**Planning Act 2008 – Section 88 and the Infrastructure Planning (Examination Procedure) Rules 2010 – Deadline 5: Comments on Coastal Geomorphology Reports**

**Application by NNB Generation Company (SZC) Limited for an Order Granting Development Consent for the Sizewell C Project**

- TR544: Preliminary design and maintenance requirements for the Sizewell C Coastal Defence Feature (Version 2)
- TR545: Storm erosion modelling of the Sizewell C Soft Coastal Defence Feature using the XBeach modelling suite

DRAWING TITLE:
 PERMANENT COASTAL DEFENCE FEATURE
 TYPICAL SECTIONS

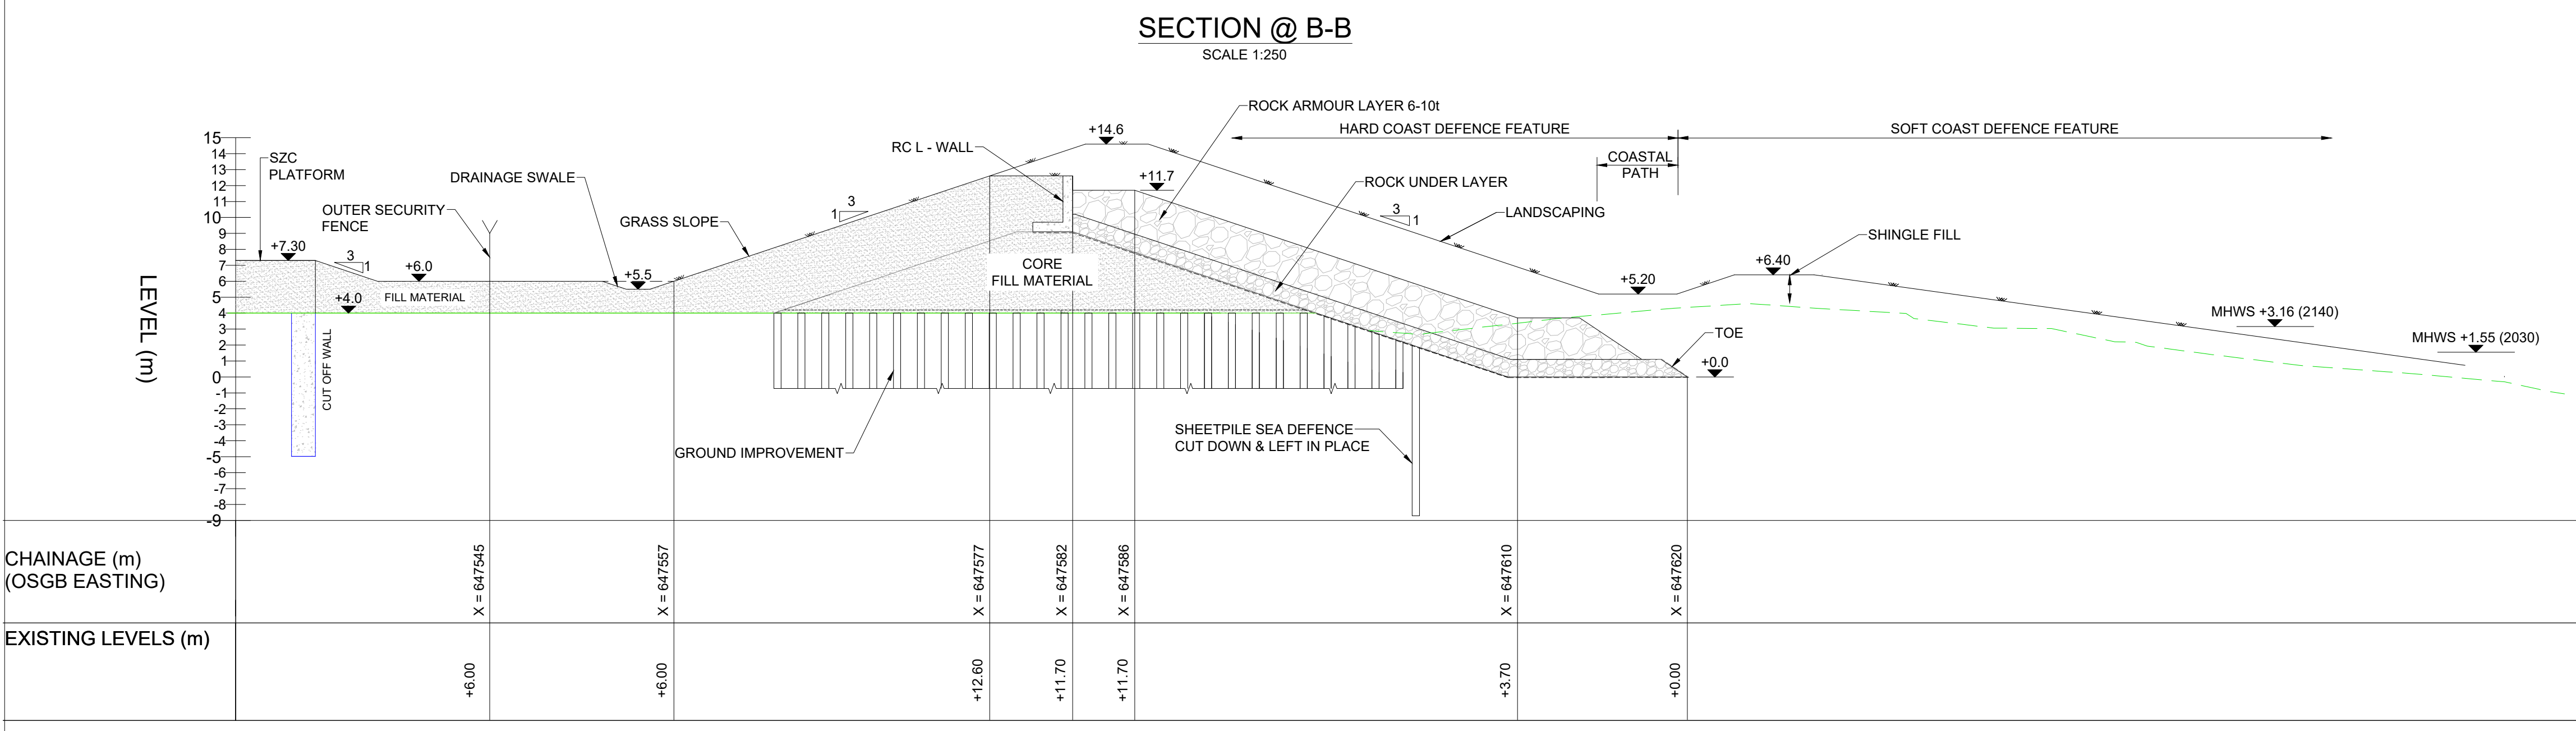
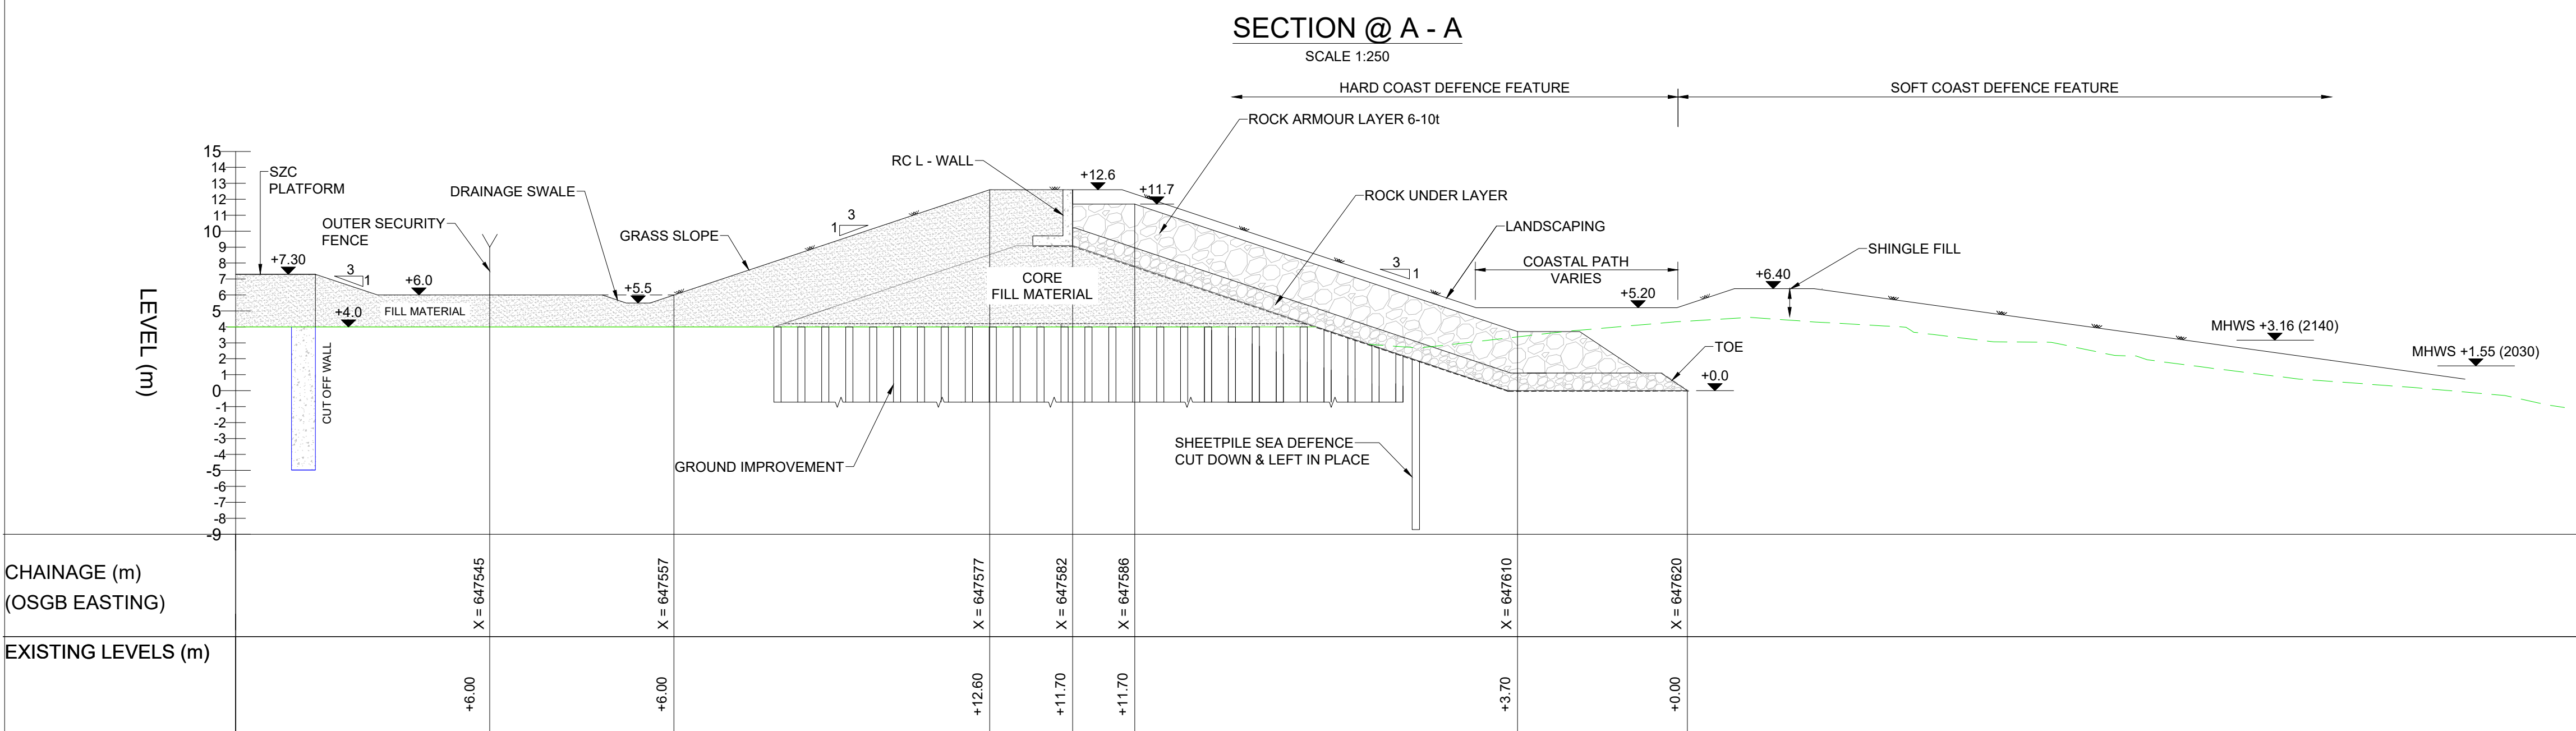
would be beneficial for the EA to see the scope for this work in advance, so that we might identify any omissions prior to completion of the work.
1.1 p. 7, 2.3.1 p. 16, 2.3.2	<p>We would question whether a high crest is indeed a valid erosion resistant feature as stated here. Artificially raised crests can actually exacerbate erosion and net sediment loss by preventing natural translation of the barrier crest in response to pressures like storms and sea level rise.</p> <p>EDF have stated (in the MTF of 02/07/21) that there will be an opportunity for further discussion about SCDF geometry, as design is still at a preliminary stage. We would welcome the chance to discuss this issue further.</p>	Encourage further discussion about the precise geometry of the SCDF at detailed design stage, in particular crest height.

4.6.2, p. 66	<p>Is there scope and intention to run the model with different crest elevations in order to examine the effect this may have on erosion rates? We generally advise against significantly increasing crest elevation (and thus freeboard) above the natural level since this risks promoting offshore sediment movement by preventing onshore transport due to overtopping / overwashing. It would be helpful to explore whether a lower, more natural crest elevation and more frequent overtopping would increase or decrease the required rate of recharge, for example.</p>	<p>Clarification of any intended further work regarding precise SCDF design.</p>
